SSD 7542 – RPA MULTI-STOREY CAR PARK PROJECT – EIS

MIKE SHARPIN
Acting Manager, Metropolitan Infrastructure
NSW Environment Protection Authority

ATTACHMENT A
- ENVIRONMENT PROTECTION AUTHORITY COMMENTS -
RPA MULTI-STOREY CAR PARK

Noise Monitoring - RPA Carpark: Tuesday 29 March, 2016

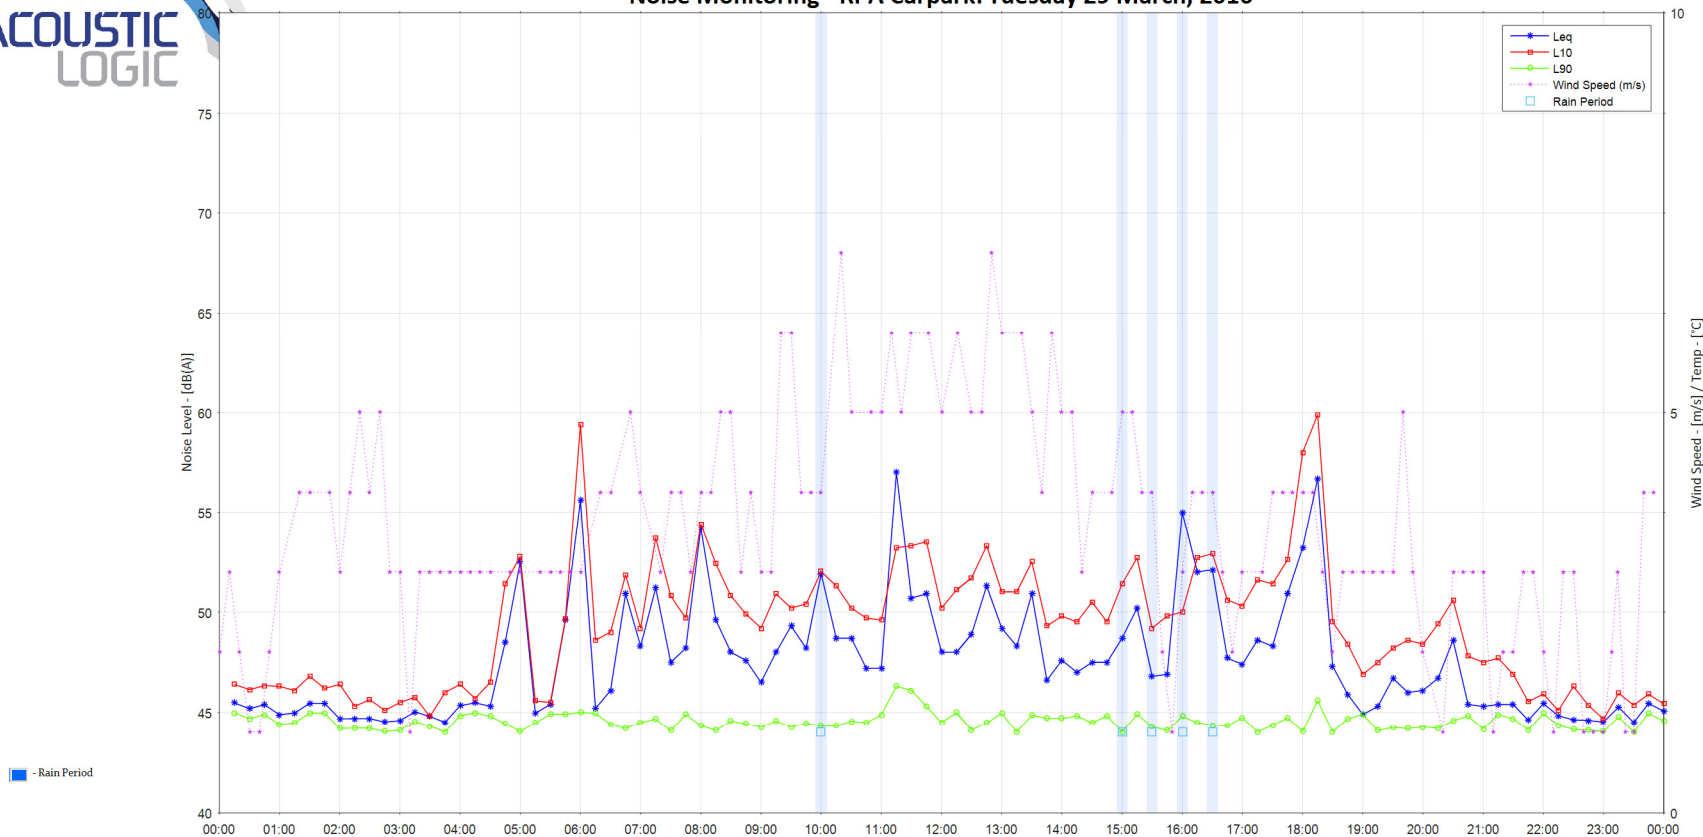
The EPA is similarly concerned that the proponent does not appear to have obtained the minimum "... one week's worth of valid data ..." anticipated by the INP for the assessment of the background noise levels (i.e. for day, evening and night-time periods), particularly given that –

- (i) no background noise monitoring data is presented until 10.00 am on 23 March 2016 (noting that wind speeds are reported as 5 metres per second or greater prior to 10.00 am);
- (ii) no background monitoring data is recorded for 30 March after 8.00 am and contrary to section 4 (2nd para) of EIS Appendix O background noise monitoring data was not presented for 31 March 2016; and
- (iii) the Bureau of Meteorology (Observatory Hill) recorded rain on 4 of the 8 days of the background monitoring period with highest daily rainfall of 34.8 mm and 7.0 mm observed on 28 and 30 March respectively. However, the rain periods shown on the background noise monitoring graph for 28 March 2016 do not appear to be consistent with the Bureau of Meteorology observations.

The INP allows noise measurements made under adverse meteorological conditions when it can be demonstrated that wind-induced noise on the microphone (and sound levels due to rain) is at least 10dB below the noise levels under investigation. However, the noise impact assessment does not provide any demonstration that wind-induced noise and rain noise was at least 10dB below the noise levels under investigation. Instead, the proponent notes in section 4 (5th para, p.8) of EIS Appendix O that wind and rain affected monitoring data have "... been omitted when determining the background noise levels at the site."

However, the EPA would consider it reasonable to adopt a night-time background noise level of 40 dBA, to ensure the noise objectives are adequately protective, particularly in regard to sleep disturbance.

- (a) (i) to adopt a night-time background noise level of 40 dBA, OR
- (ii) provide a quantitative assessment of the 'night-time' background noise level measured at the most affected residence (corner of Fowler and Church Streets and in accordance with the guidance material provided in the New South Wales Industrial Noise Policy. And, identify the dominant and background noise sources present at the site throughout the monitoring period (including "identification and occurrence of noise sources" in accordance with INP B1.2)
